Department of Transportation

September 25, 2018

RE: Smith Farms Agritainment, PPR1818

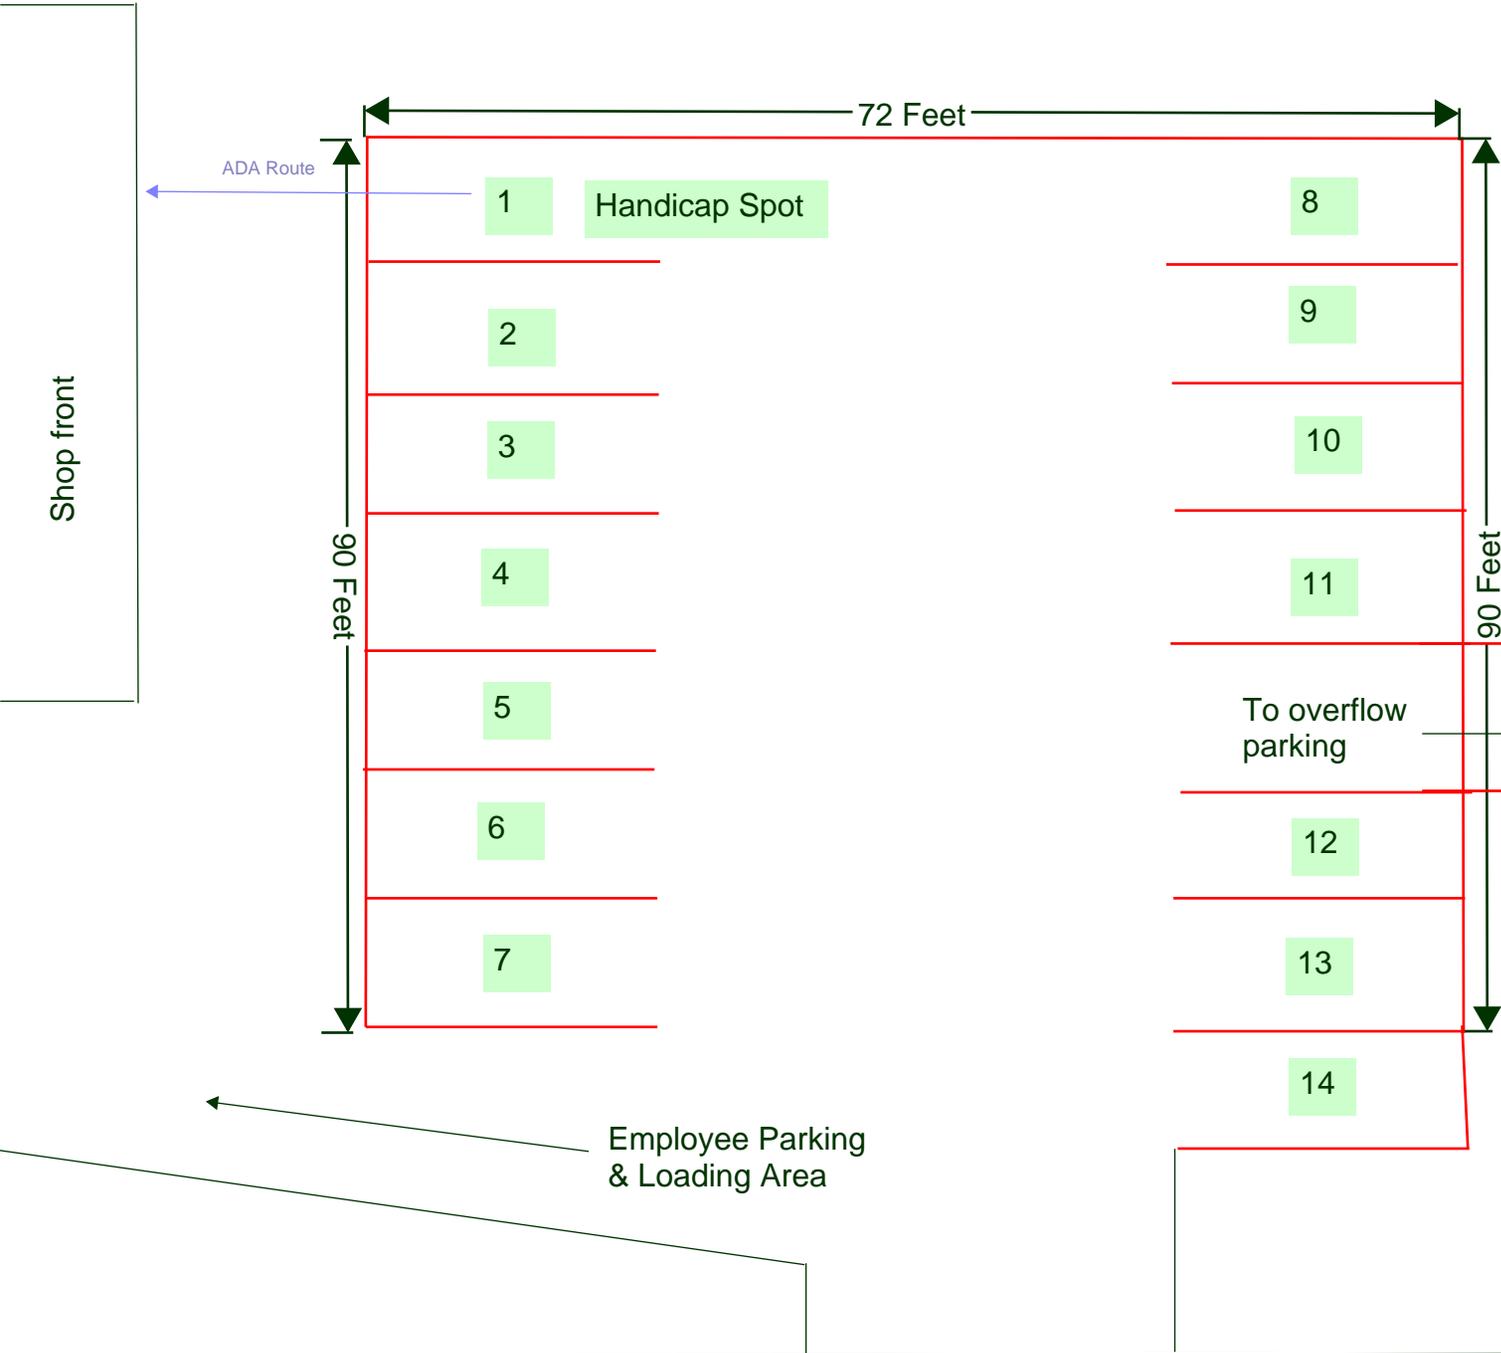
- Due this development originally being a vacant lot and now a proposed Agritainment Facility with farmers' market this development will be required to apply for a Colorado Department of Transportation Access Permit for the access of Blue Gill Dr. and SH24. The change in land use rules apply as spelled out in the State Highway Access Code 2002, Section 2.6, Changes in Land Use and Access Use.

- In accordance with El Paso County 2016 Major Transportation Corridors Plan, CDOT is requesting R.O.W dedication adequate enough to accommodate the future condition of 6 lanes on US24 in accordance with the El Paso County Land Development Code chapter 8.4.4 sect.(b).

- It is also understood that Blue Gill Dr. will be realigned to intersect with Judge Orr Rd. and Judge Orr Rd. will be realigned with SH24 in the future. It is suggested that the access and permanent structures to the subject parcel not be within the proximity of this future realignment. The realignment plan has not, yet been determined and is not mentioned as part of the established Access Control Plan.
